Application for a non-material amendment following a grant of planning permission.

Change of use of premises from Class B8 to B1c/B2/B8, including internal and external alterations, demolition of ancillary structures and new access to Southam Road

Reference number:	<input type="text" value="18/01246/F"/>
Date of decision	<input type="text" value="20/12/2018"/>

Omission of accessible ramp. Alterations to office cladding configuration and colour. 2no level access doors increased in size. Existing CAT ladder omitted. High level strip glazing extent reduced.

Banbury 200 Unit,
 Southam Road, Banbury
 Proposed Site Plan

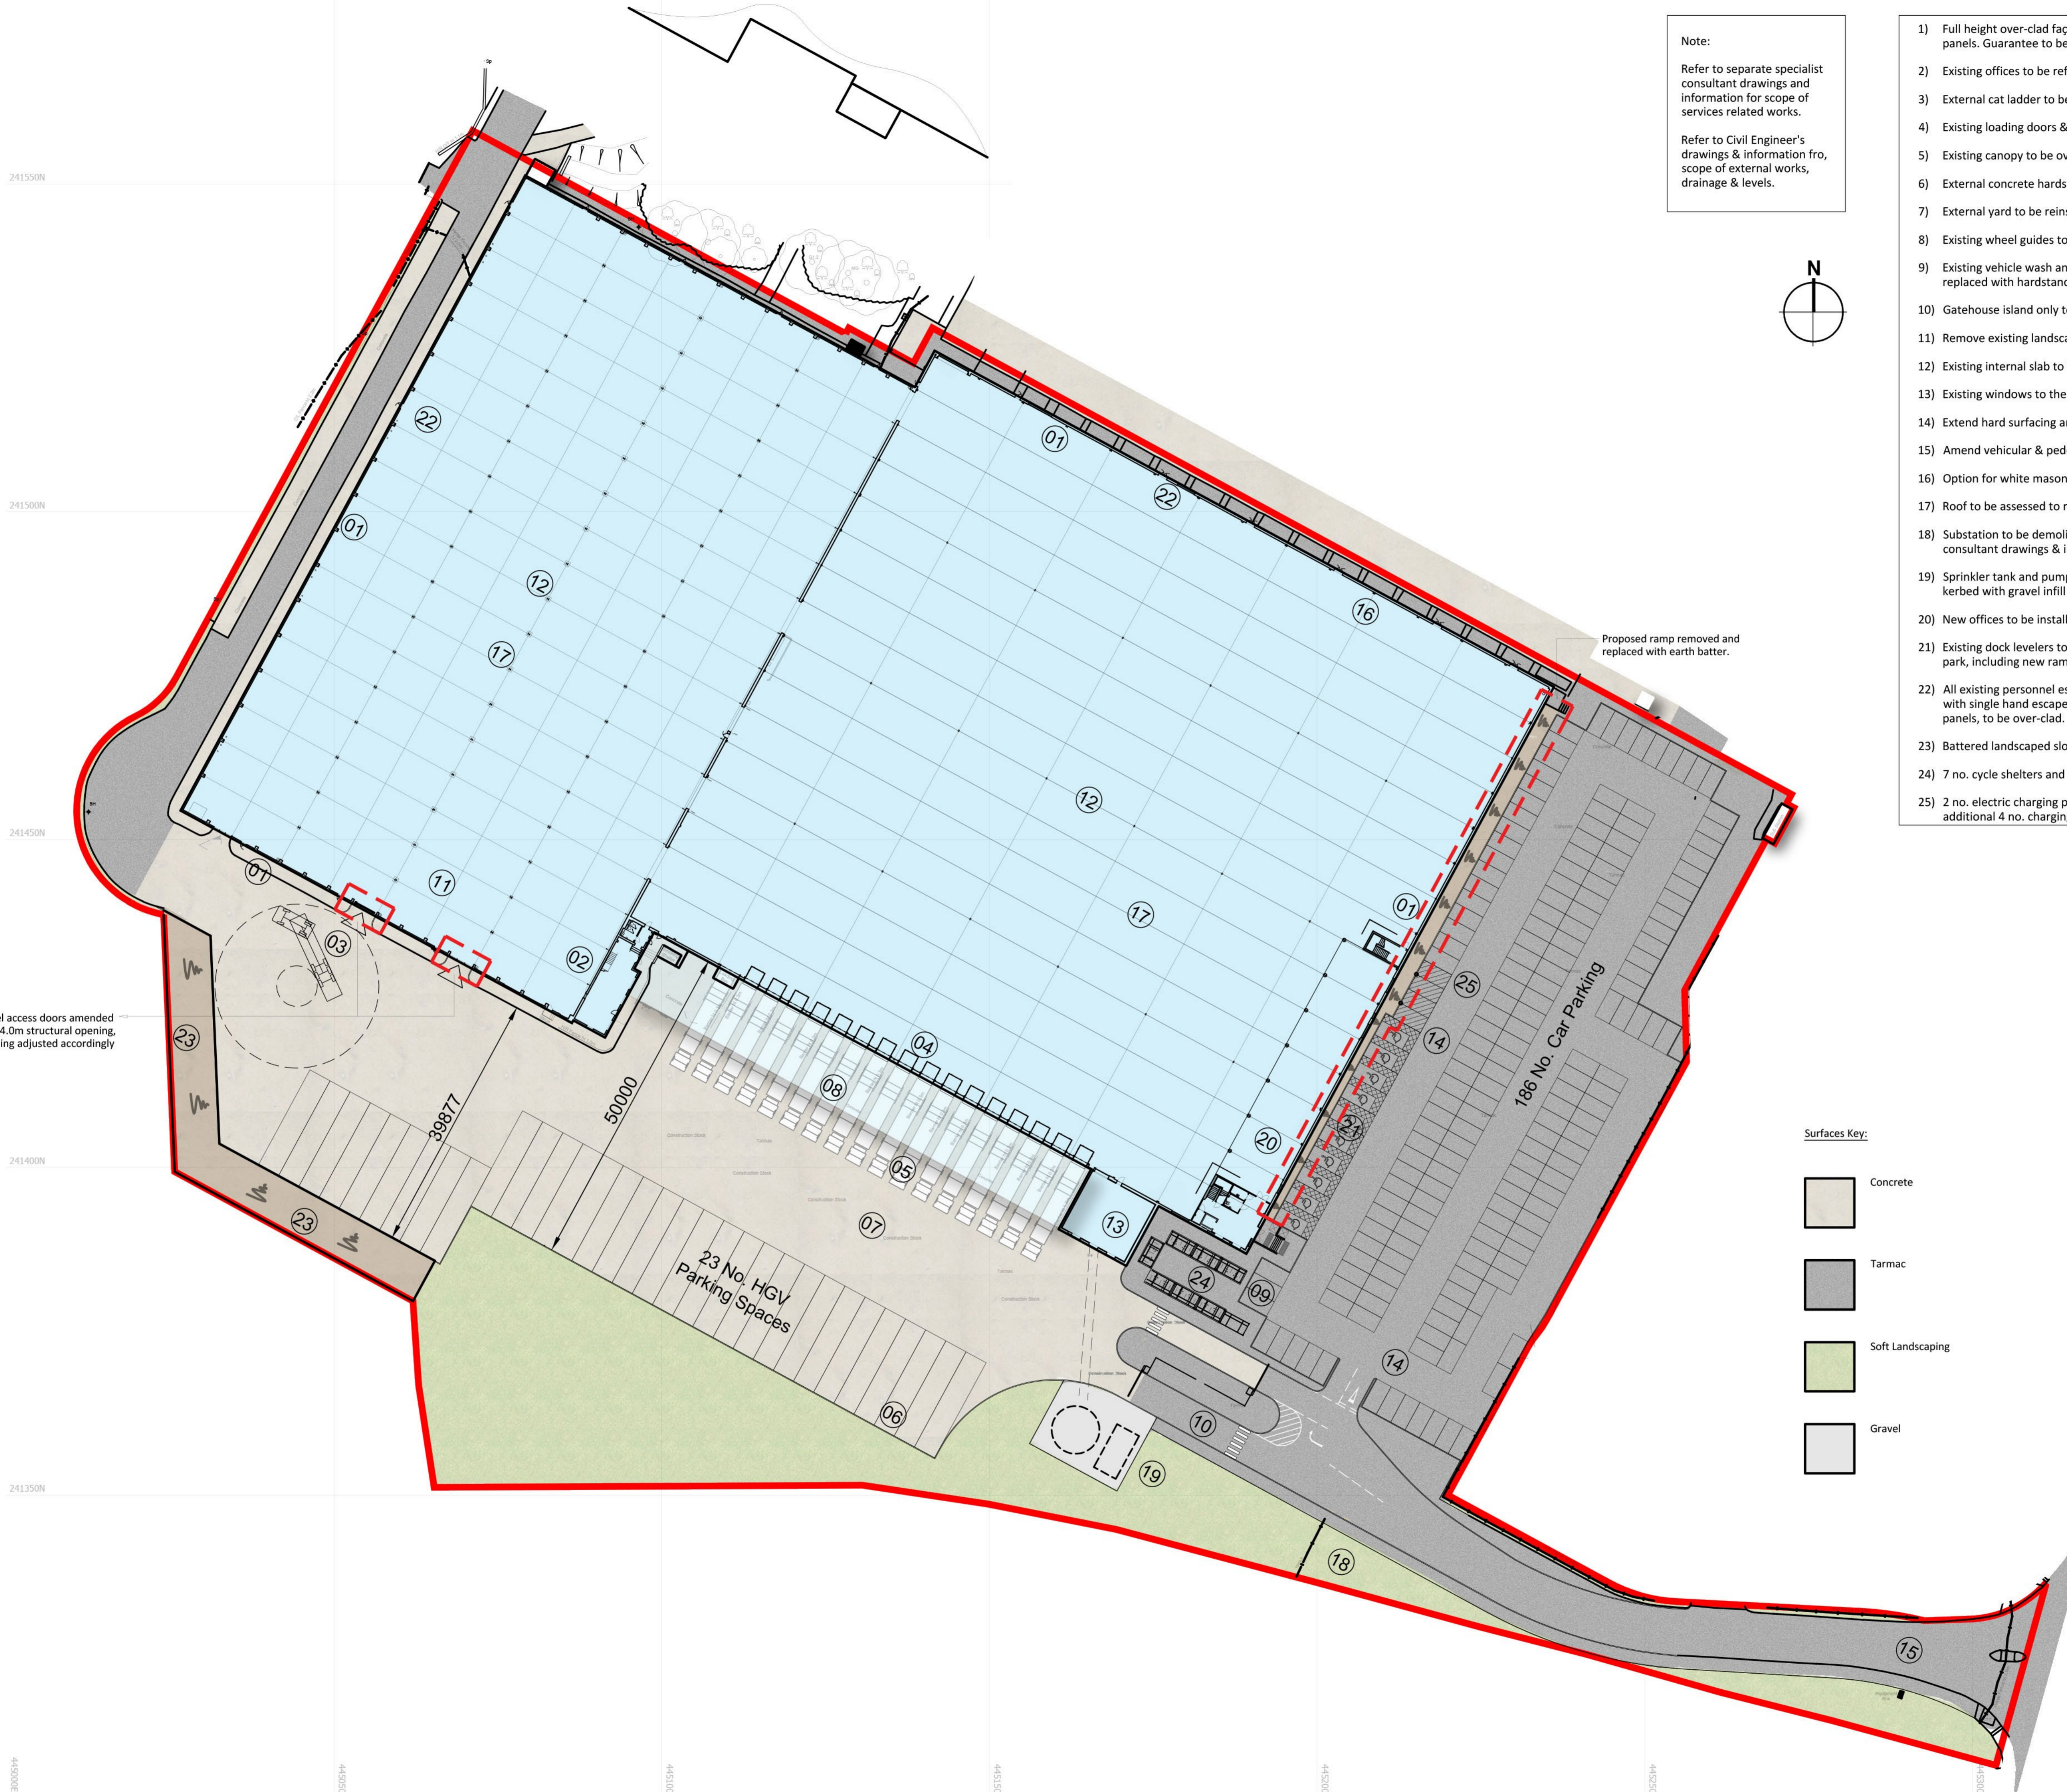
16083 P 003 Rev U - Proposed Site Plan
16083 P 008 Rev F - Proposed Elevations

16083 P 0002 Rev A - Proposed Site Plan
16083 P 0001 Rev A - Proposed Elevations
